APPLICATION NO. 03DRB00894	PROJECT NO. 1002512
PROJECT NAME Tract A, Lands of Petty	
EPC APPLICATION NO.	
APPLICANT / AGENT Wilkes	PHONE NO. 888-3066
ZONE ATLAS PAGE L9

DRB CASE NO/PROJECT NO: 1002512

CITY OF ALBUQUERQUE
Planning Department
6/11/03

Subject: Site Development Plan for Building Permit/EPC

A SIGN DETAIL  
N.T.S.

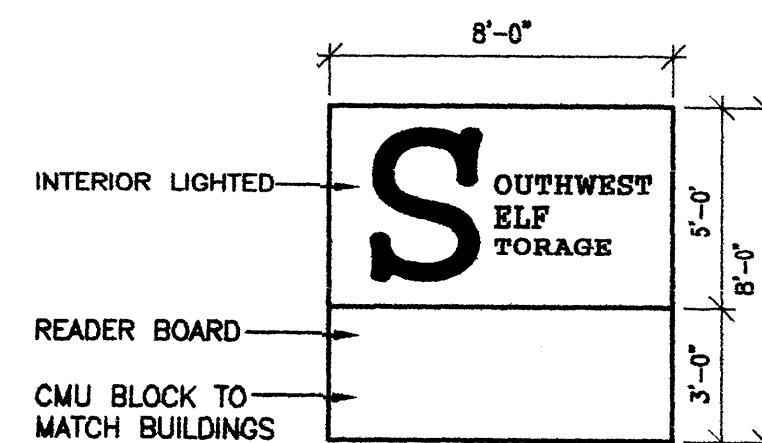
- ✓1) The language regarding the lighting (i.e. foot lamberts) needs to be verified against the regulations.
- ✓2) Staff needs to verify the type of notices to be placed on the signs reader board at the corner of 98th Street SW and San Ygnacio Rd SW.

SHEET NUMBER: ST-1

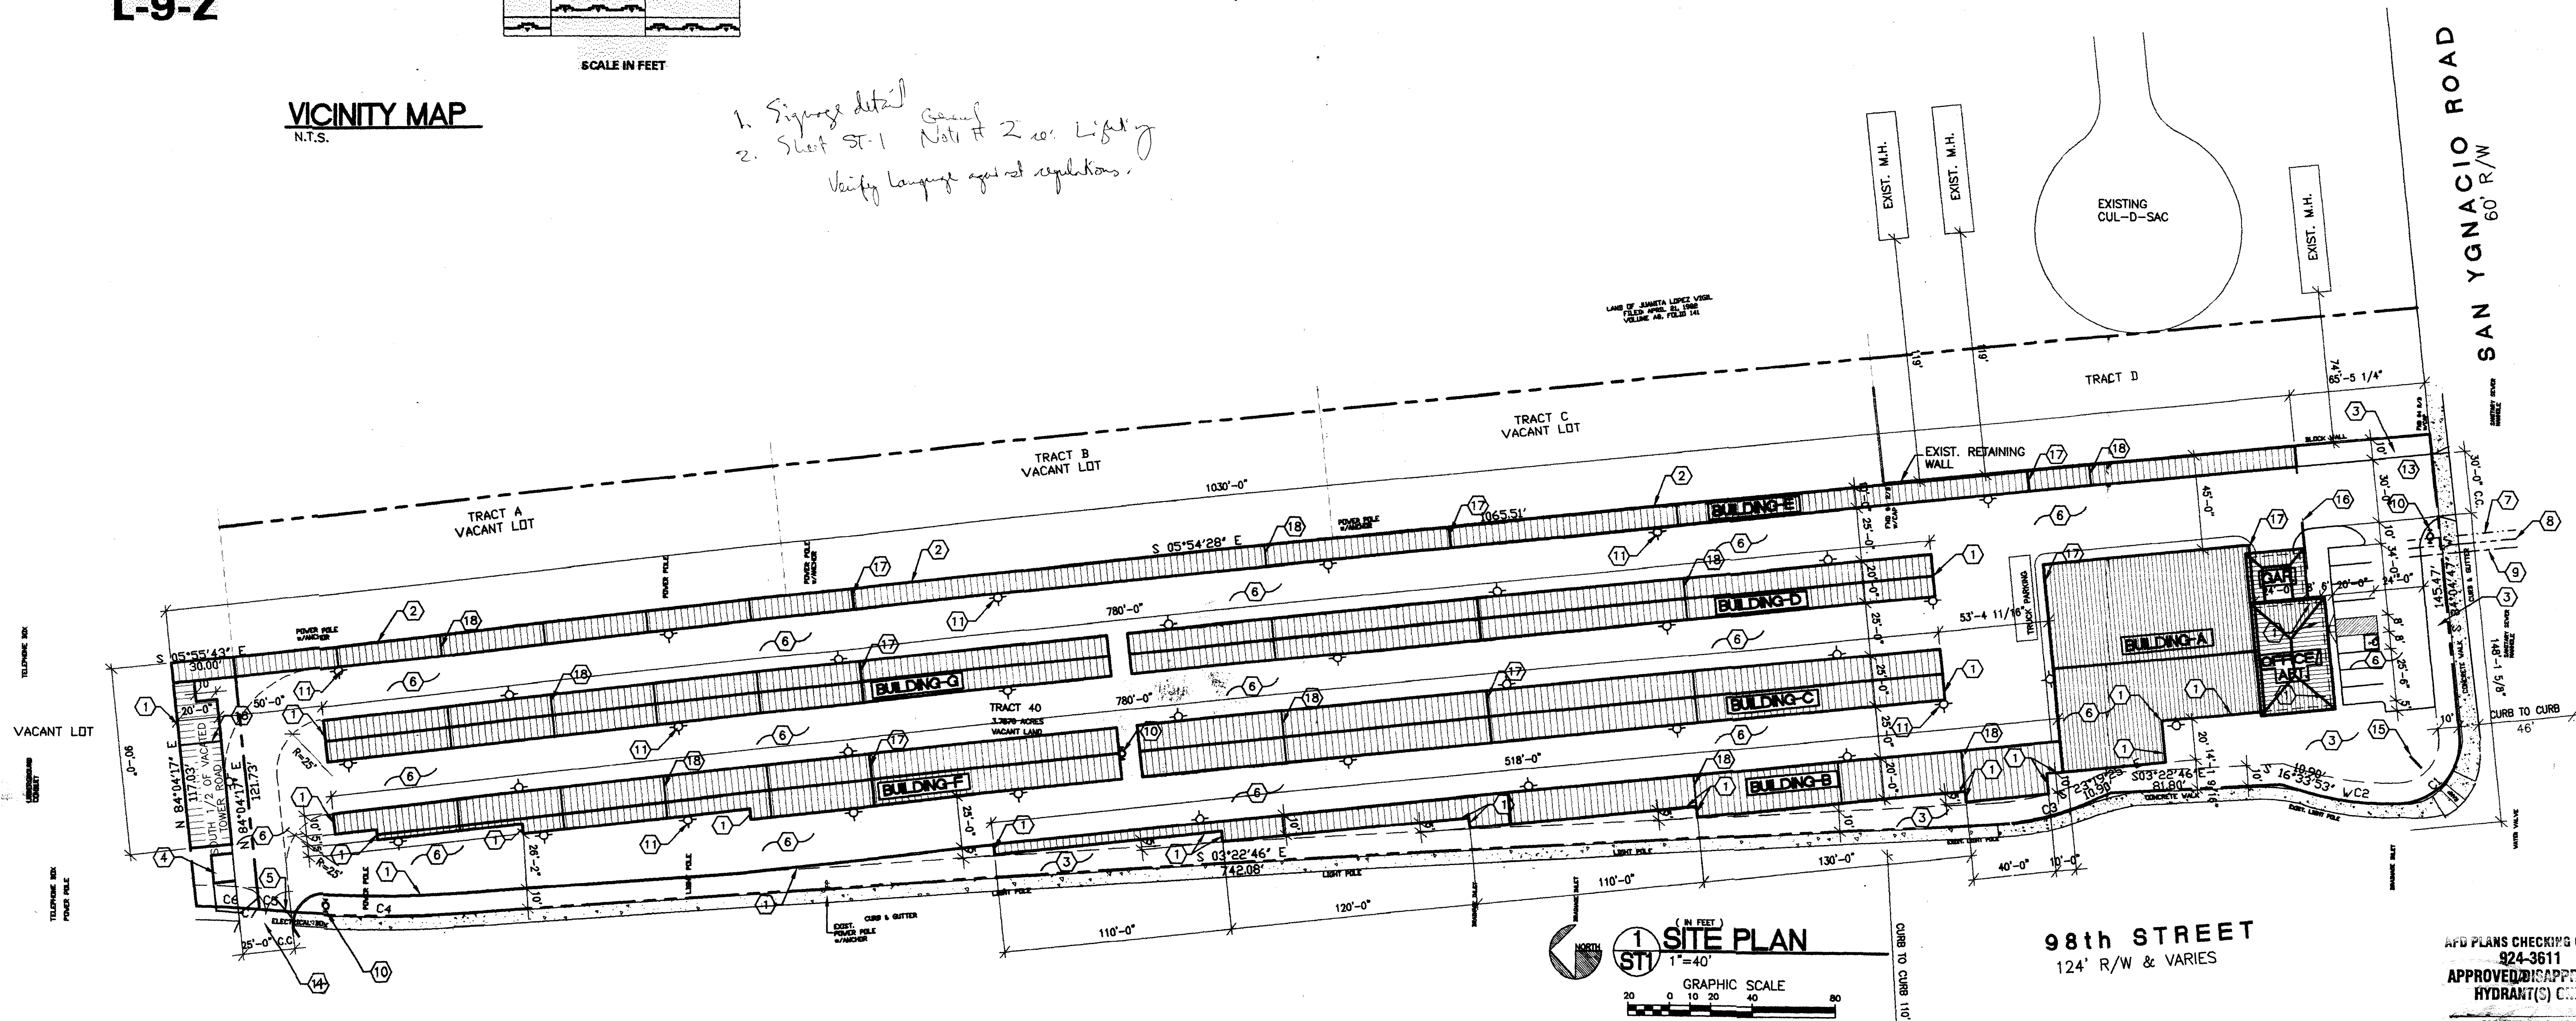
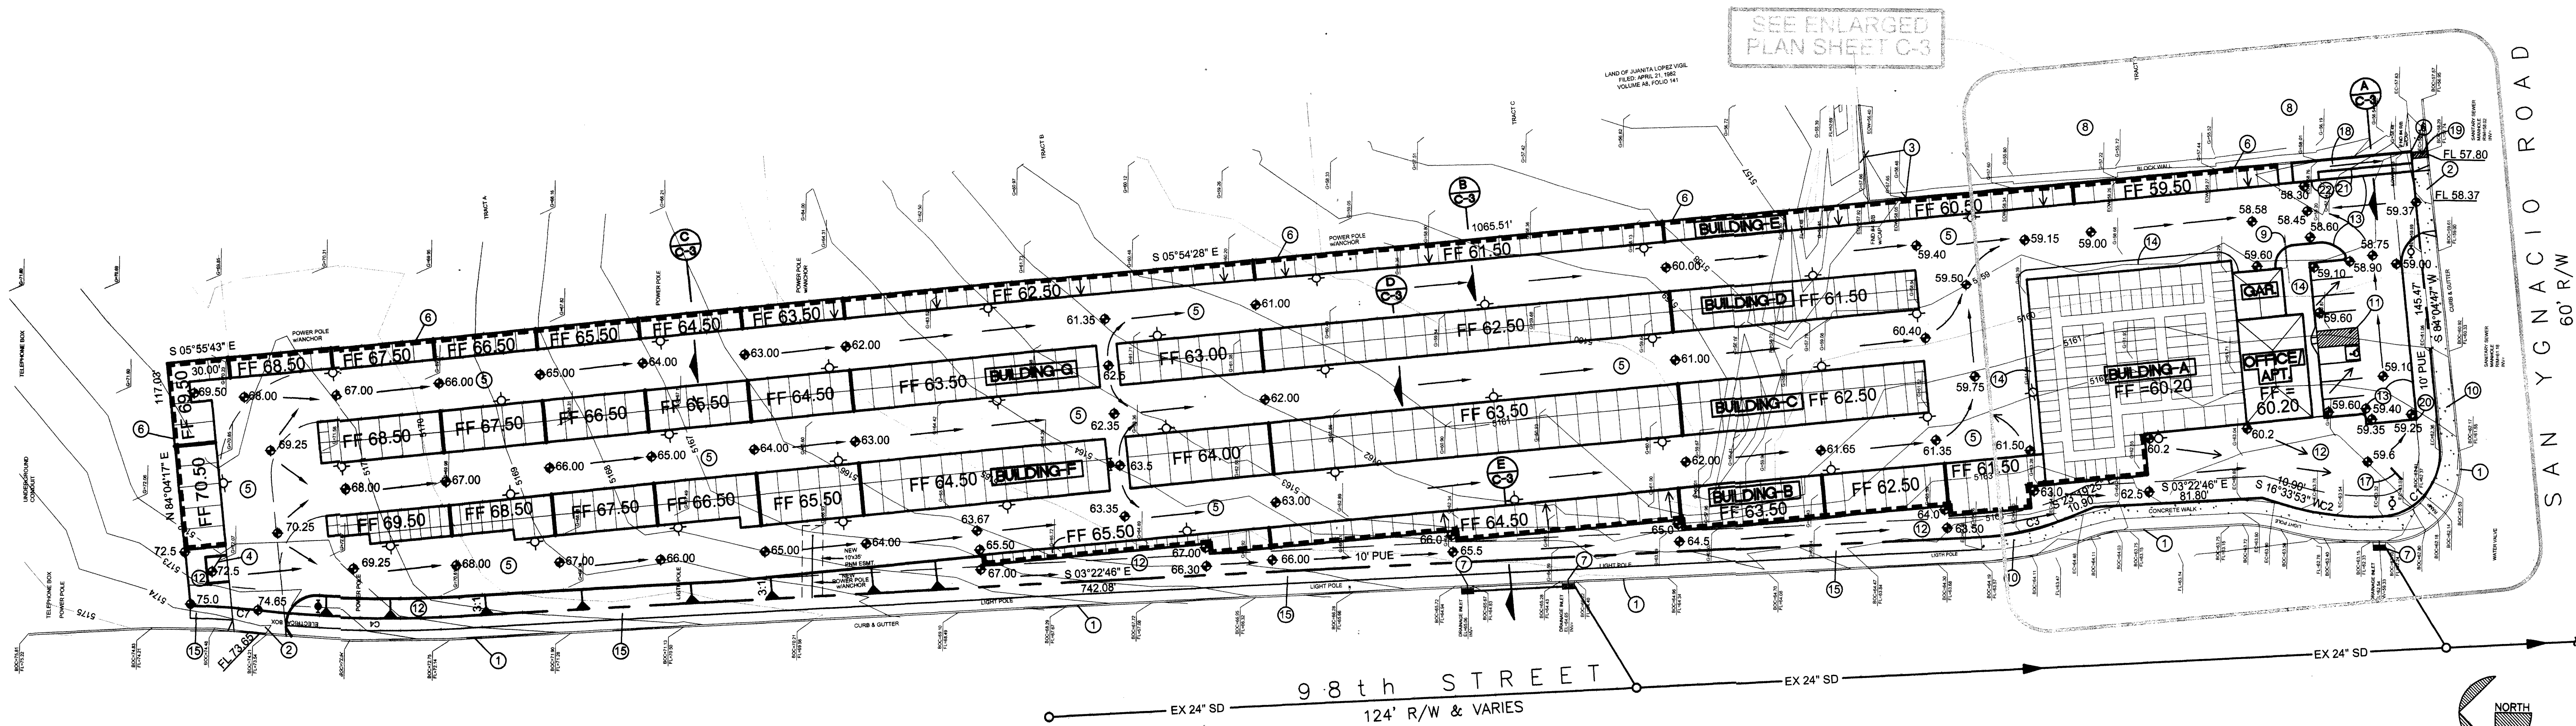
- Stripe some end islands at the end of the storage buildings.
- No objection to the plat.
